RE: SUBMISSION TO SSD-82900461, CONCEPT PROPOSAL FOR CONSTRUCTION OF 9 STOREY RESIDENTIAL FLAT BUILDING WITH IN-FILL AFFORDABLE HOUSING

Address: 11-19 Middle Harbour Road, Lindfield

Ku-ring-gai Council's objection to SSD-82900461, Concept proposal for construction of 9 storey residential flat building with in-fill affordable housing at 11-19 Middle Harbour Road, Lindfield

## GROUND FLOOR LANDSCAPE PLAN

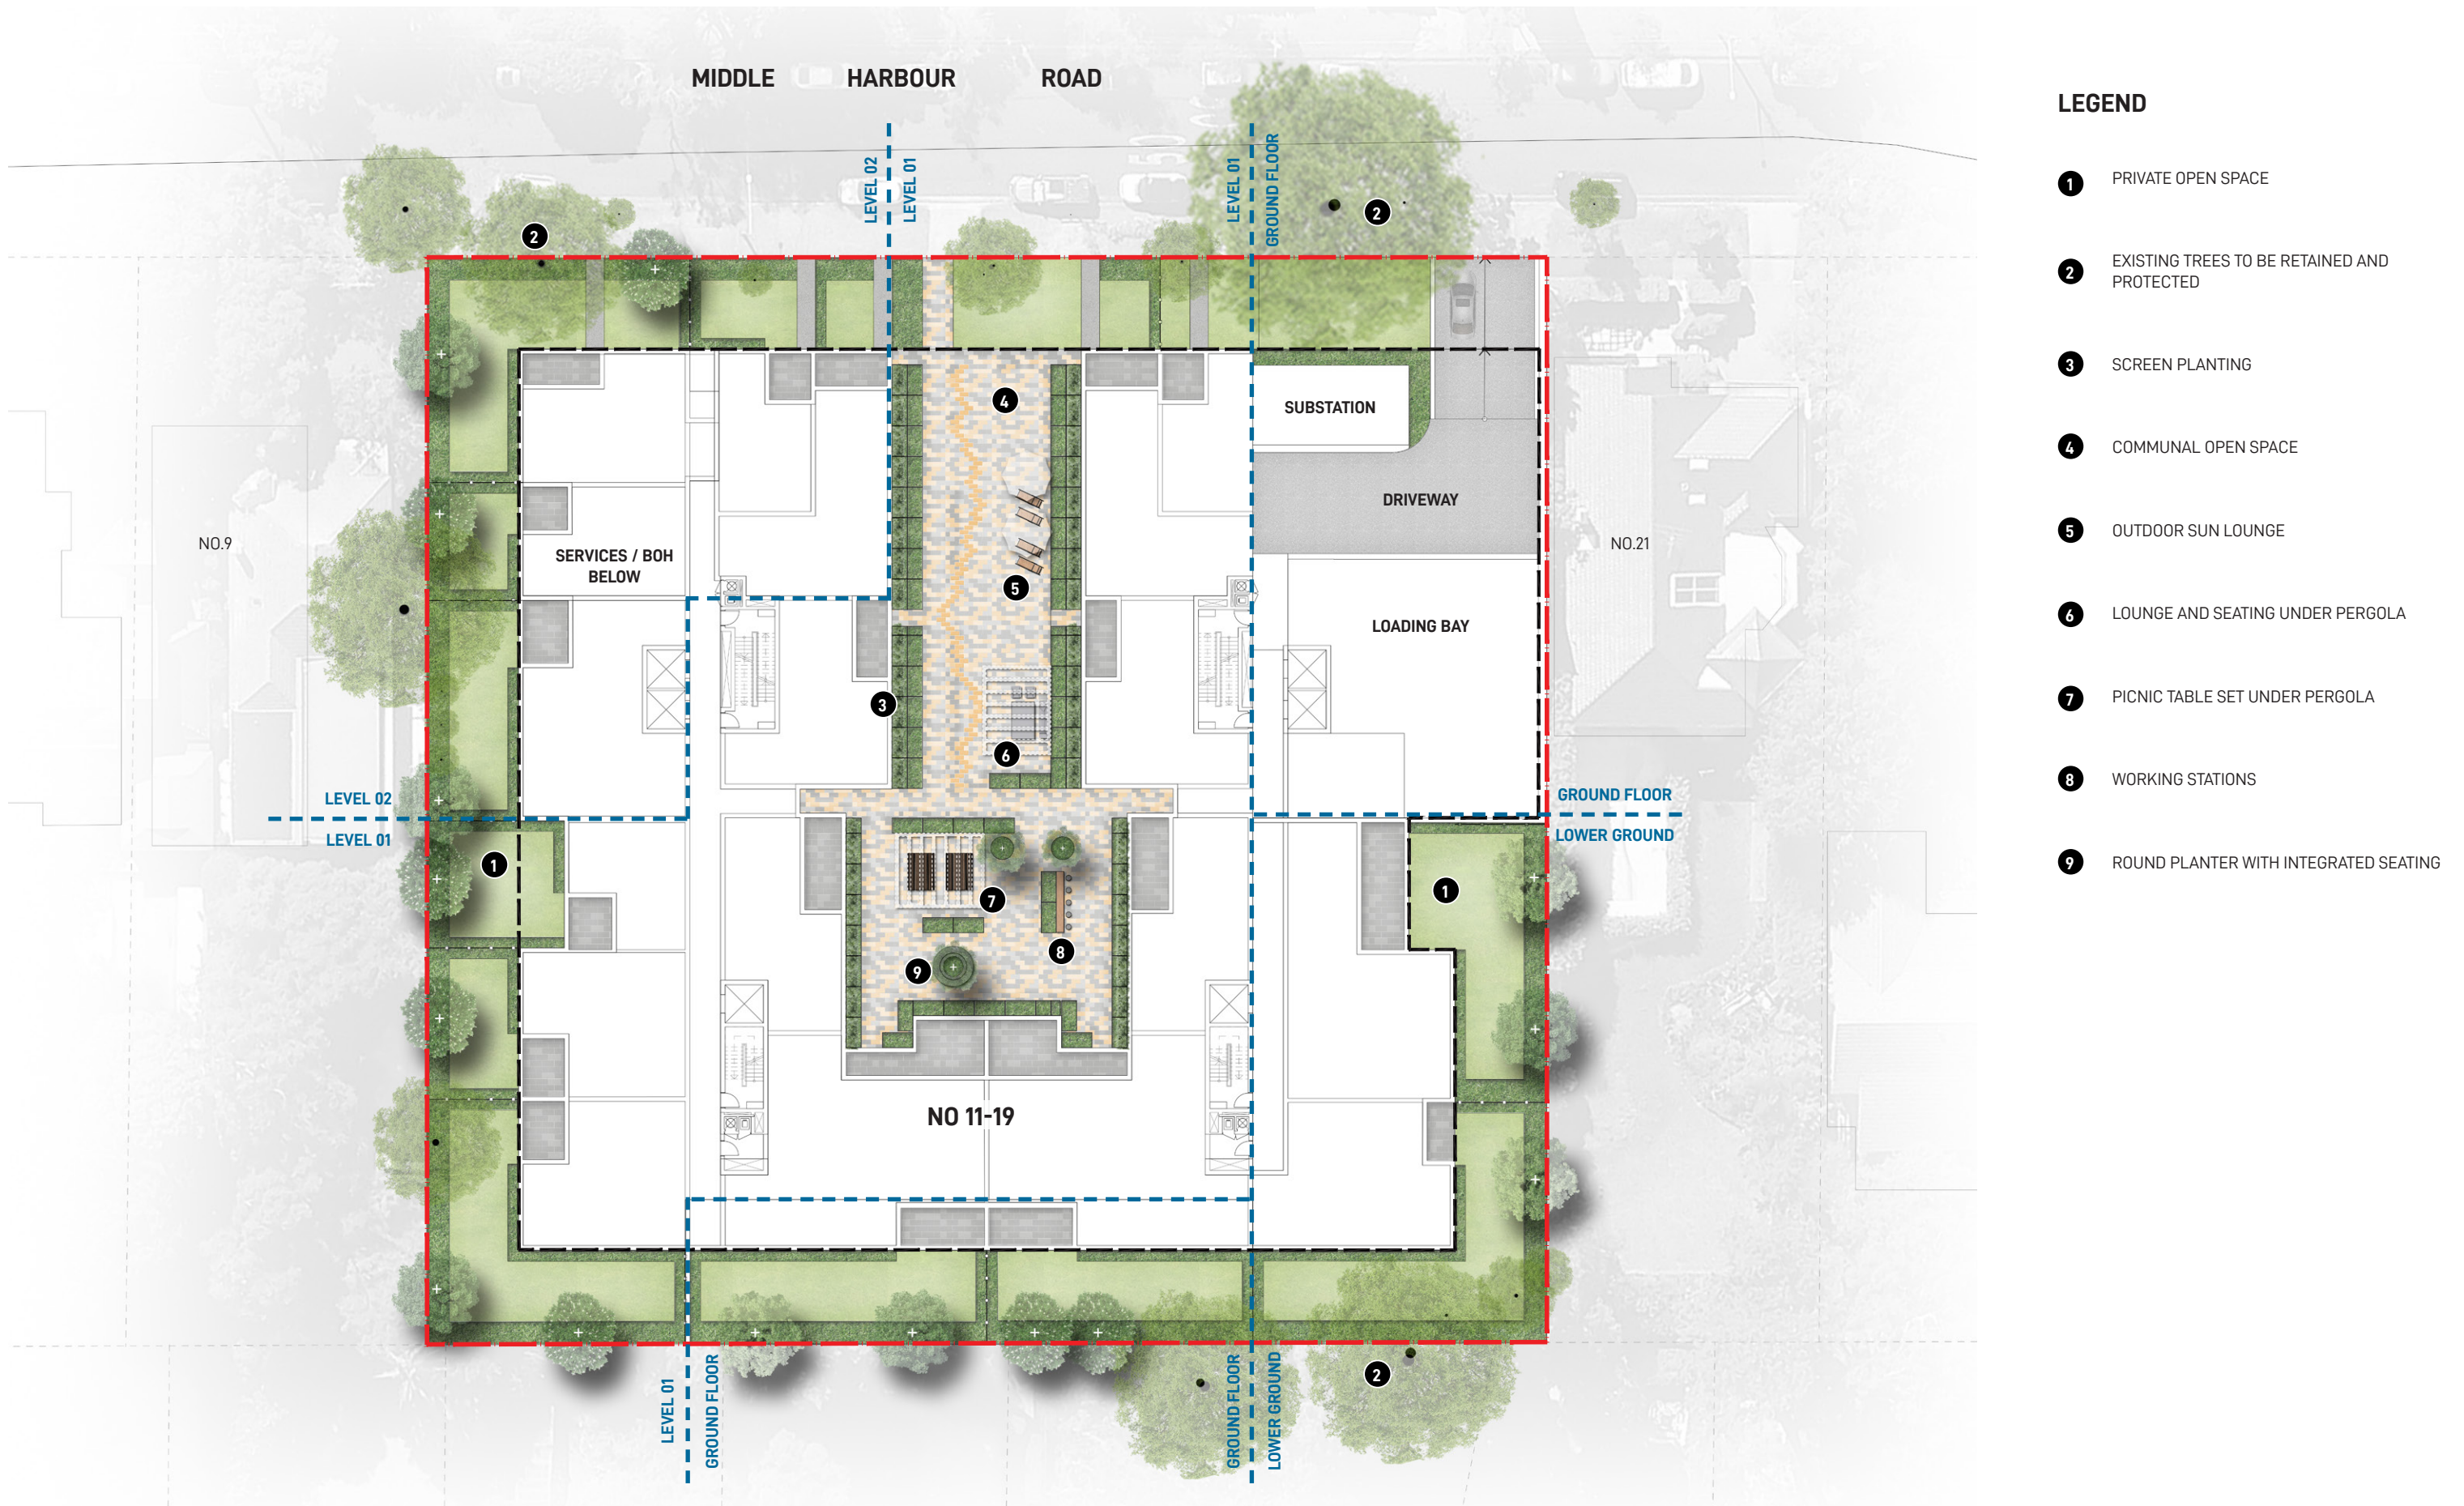
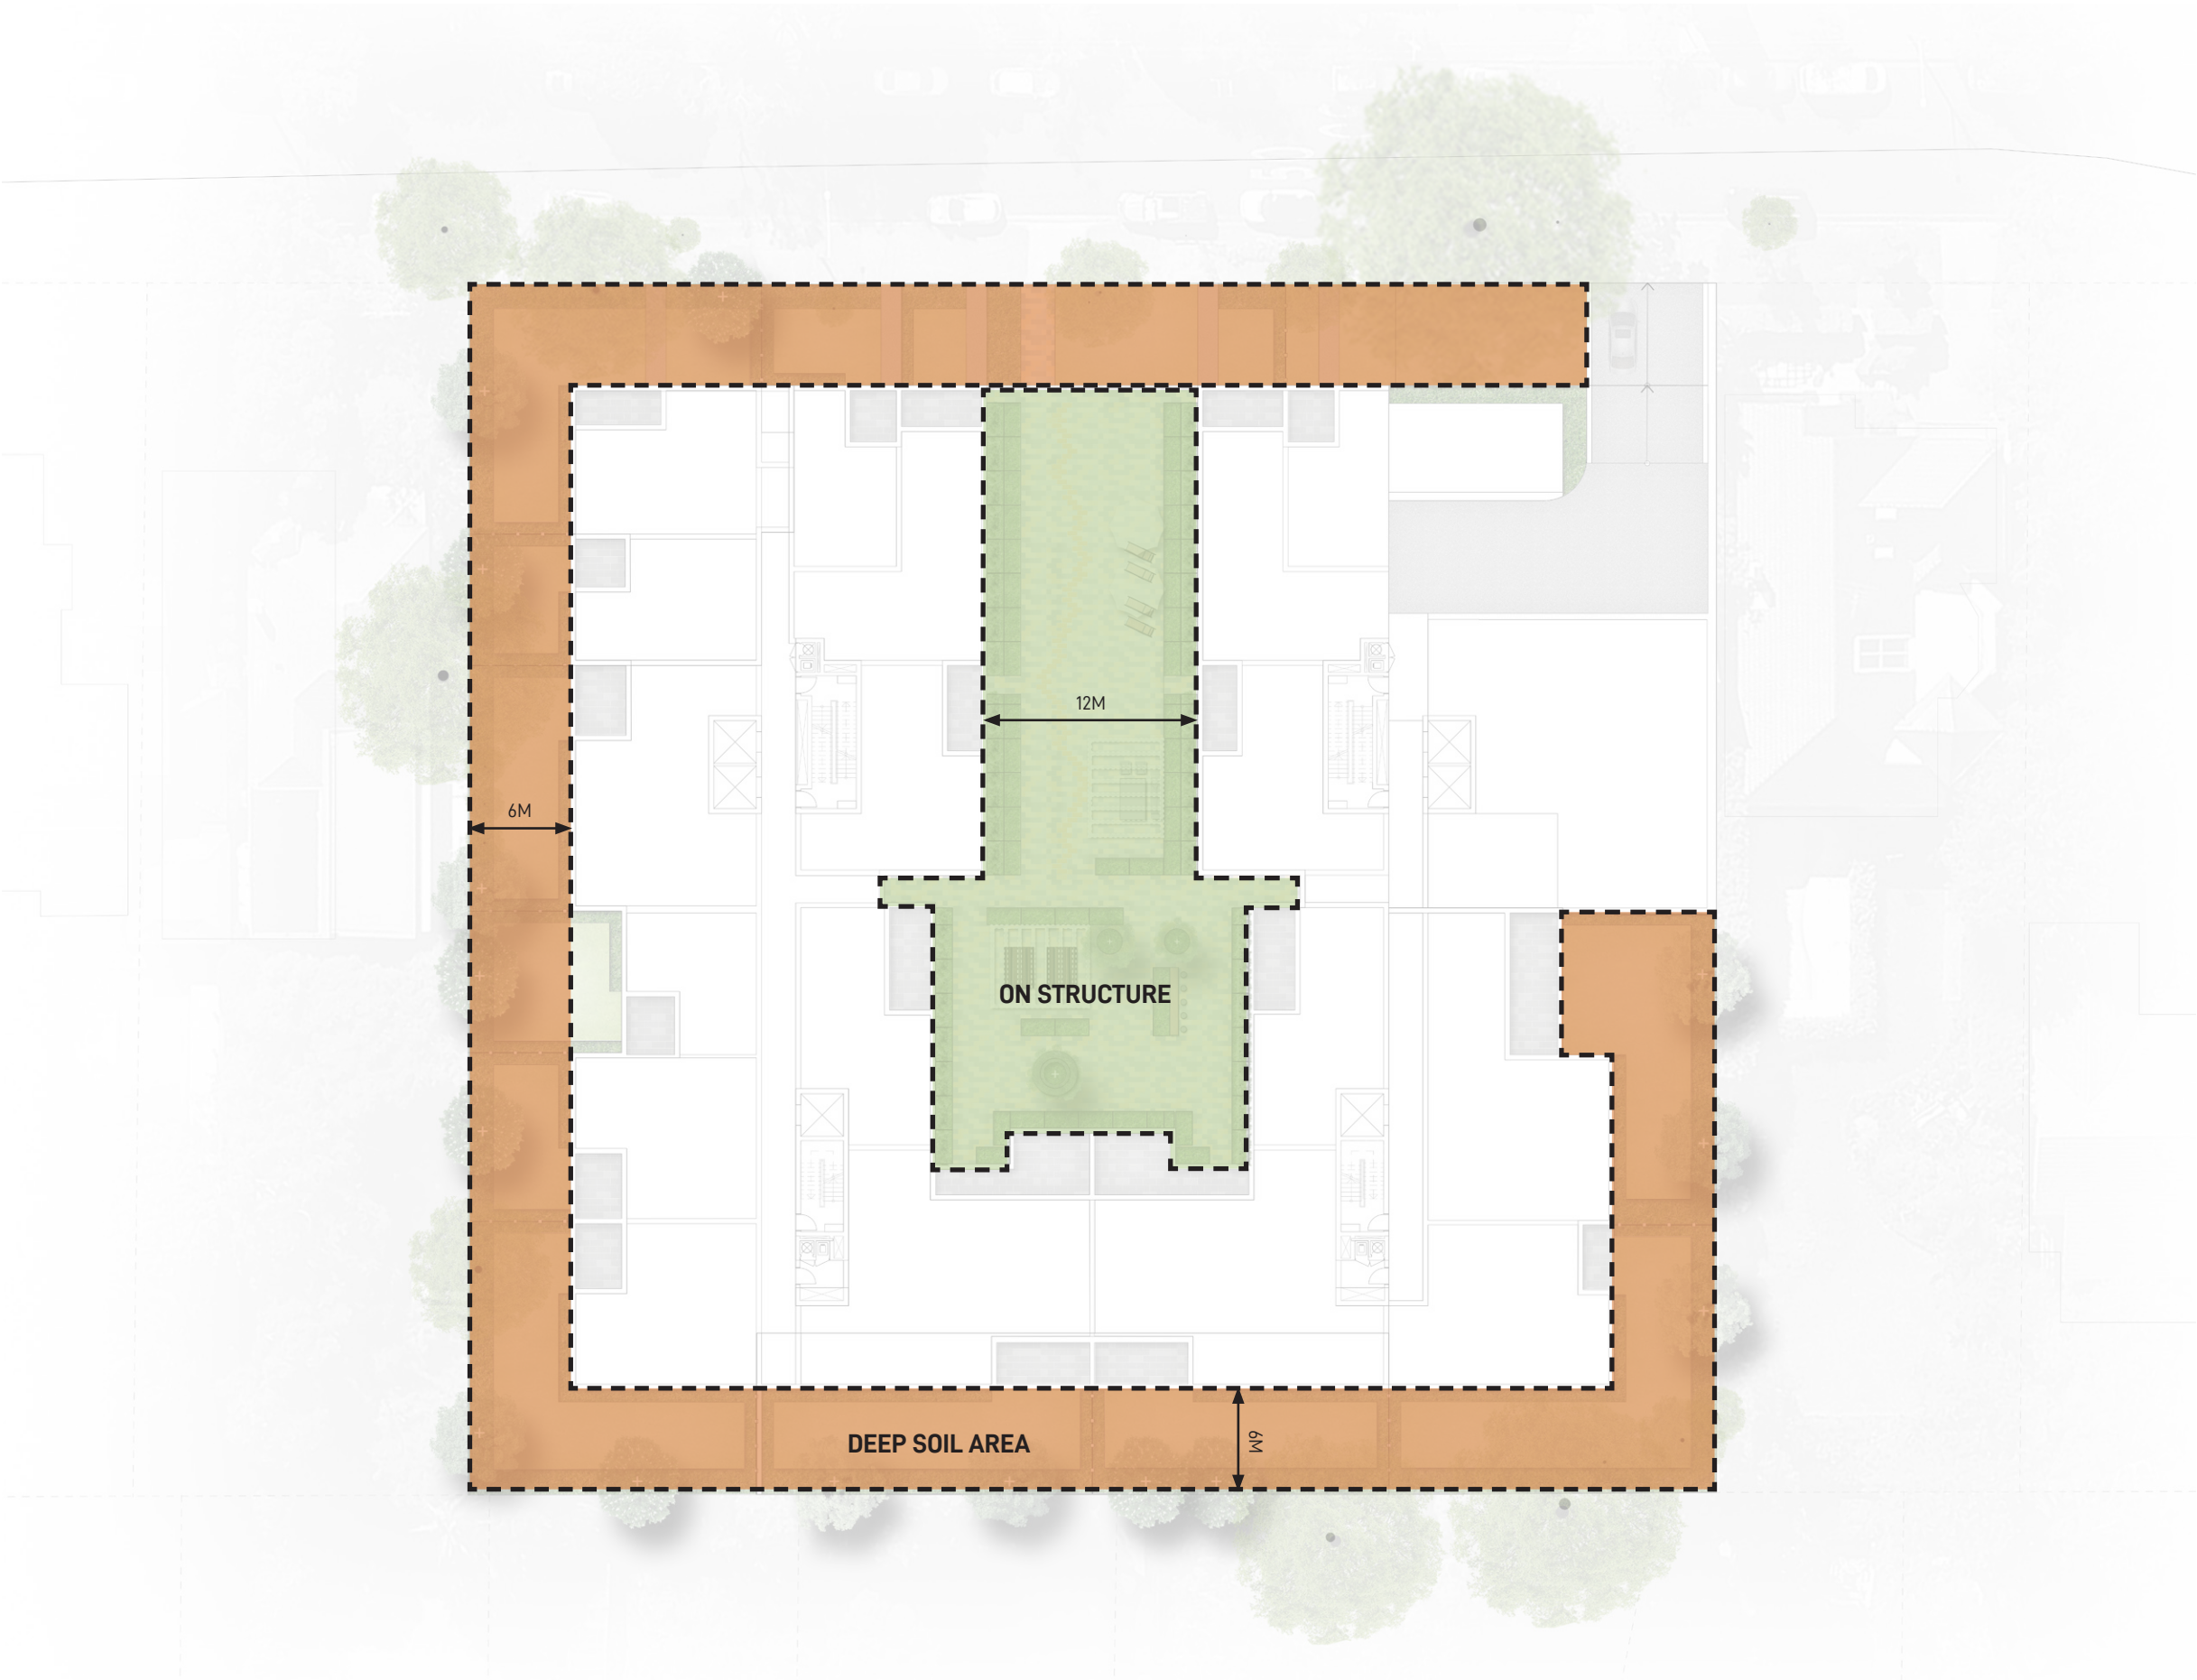
It is also noted that nominated deep soil areas are contained within private open spaces and will likely restrict the ability for tall canopy trees to be planted and maintained. Tall canopy trees and deep soil areas are required to contribute to canopy cover and the landscape character of the locality. Council recommends that deep soil areas are provided within communal open spaces to achieve landscape objectives and requirements in Part 3E of the ADG and Part 7A.6 of the KDCP.

The proposed planting above structures in individual pots instead of built in planter beds undermines the practical establishment and long-term viability of the proposed landscape design outcomes above structures and is not supported.

The proposed landscape plan contains insufficient information to enable a proper assessment of impacts of tree removal, retention of existing trees, proposed tree canopy and landscape area for the site. In particular, the landscape plan is not supported for the reasons as follows:

- Principal areas of deep soil should be located within communal open spaces rather than within private open spaces.
- 18 tall trees with a minimum height of 18m at maturity are to be attained for the site as required in Part 7A.6 of the KDCP. Tall trees must be planted at least 2m from any boundary, and 4m from any structure. Tree planting is to be distributed across all setback areas, with at least 30% located within the front setback.

- The proposal shall design built-in planting areas that contributes positively to the streetscape. Raised planters shall meet the requirements of Part 4P of the ADG. Permanent, well-integrated planting solutions with low water requirement planting and known to perform well in proposed restricted areas are required to ensure long-term success and visual quality.
